CITY OF PORTLAND, MAINE
PLANNING BOARD

Project Name:	Canal Plaza Hotel	Project ID:	2012-558
Address:	433 Fore Street	CBL:	32-I-40
Applicant:	Cow Plaza Hotel, LLC, Applicant		
Planner:	Nell Donaldson

PLANNING BOARD REPORT PORTLAND, MAINE

Canal Plaza Hotel
433 Fore Street
Level III Site Plan Review
2012-558
Cow Plaza Hotel, LLC, Applicant

EXHIBIT-06

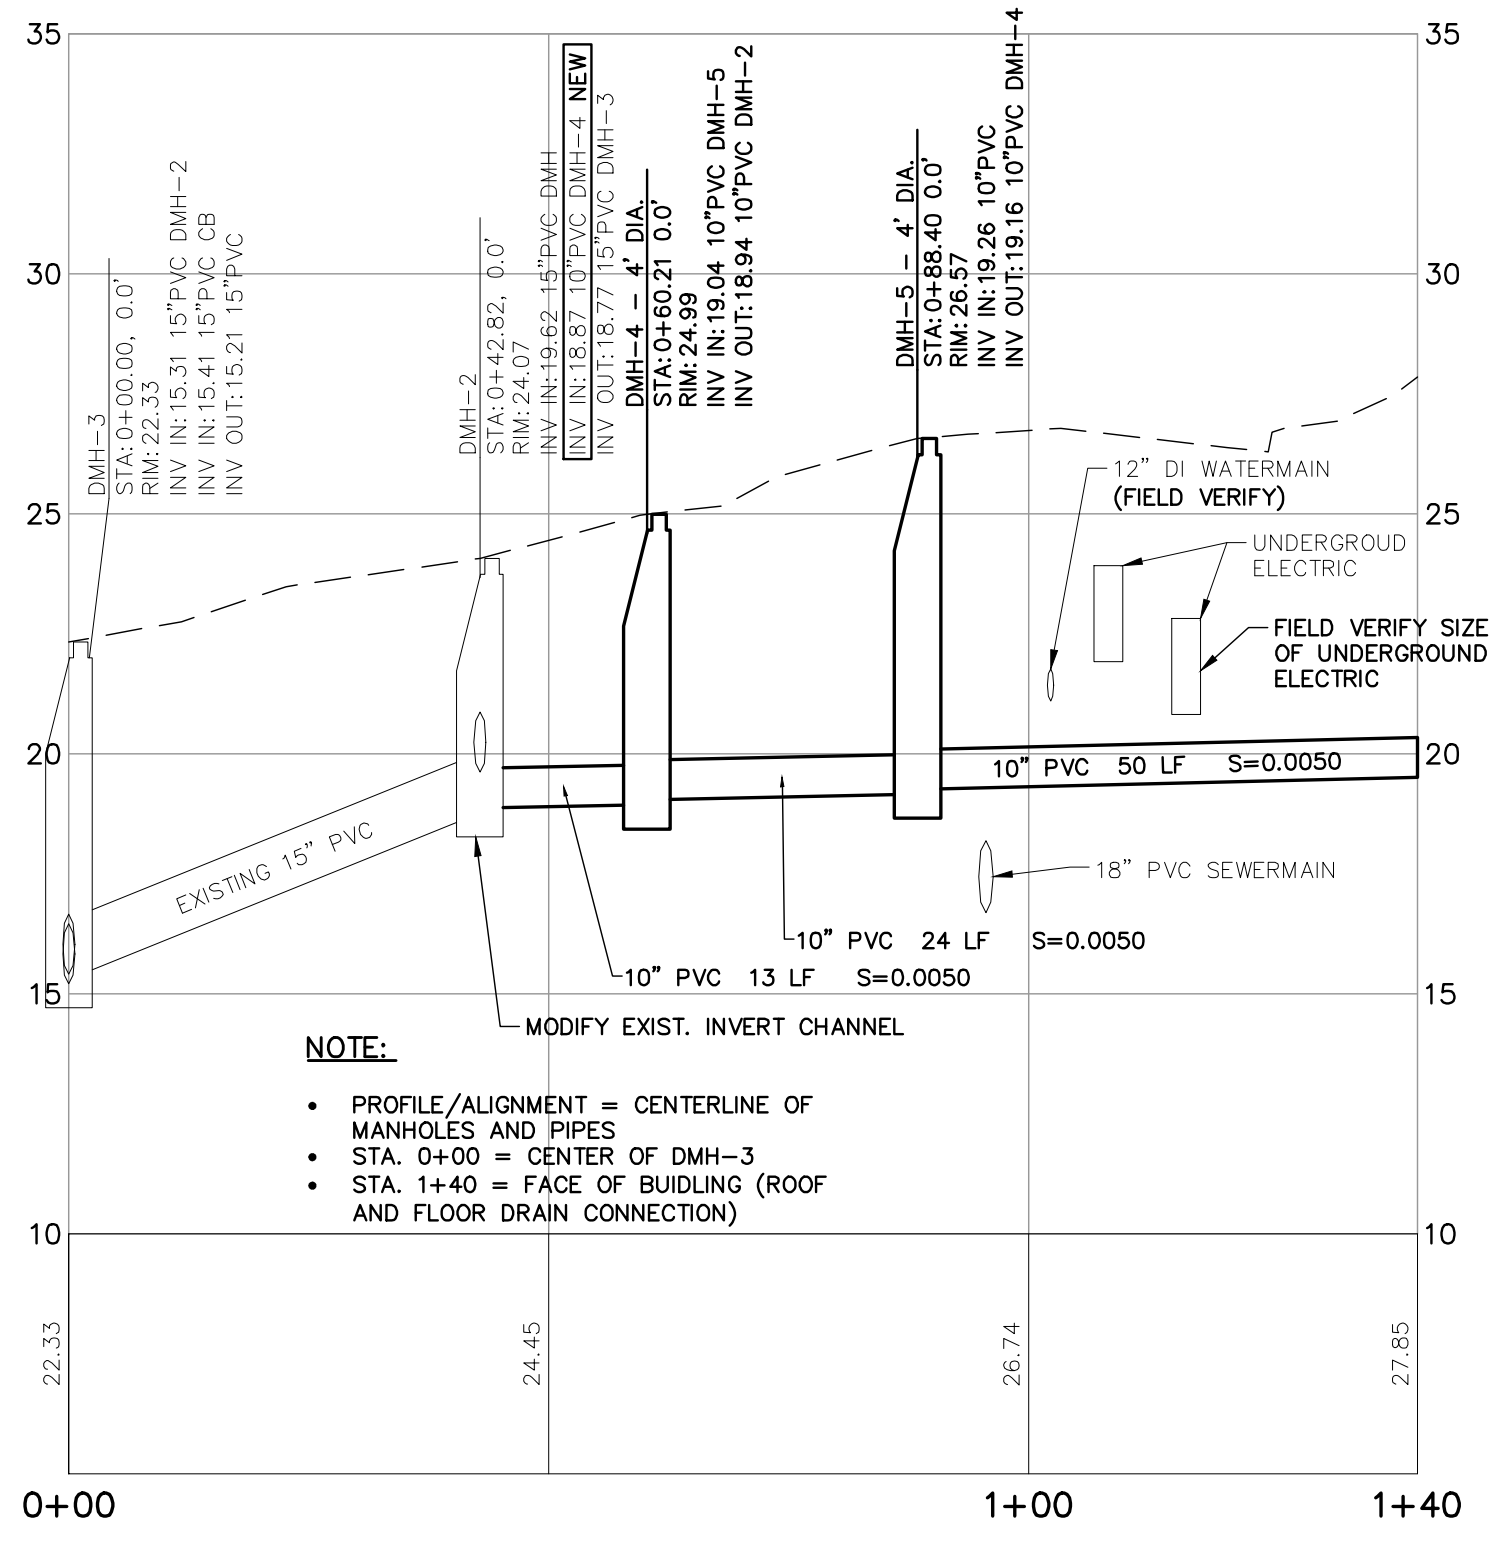
1. The applicant shall revise the final plans prior to the issuance of a building permit to include:
 - a) A “Do Not Enter” sign at the egress drive location on Union Street

6. The applicant shall revise the site plan to include notes indicating the final location of the existing mast arm, the final location of the controller cabinet, and the final location of the pedestrian signal heads, for review and approval by the Department of Public Services;
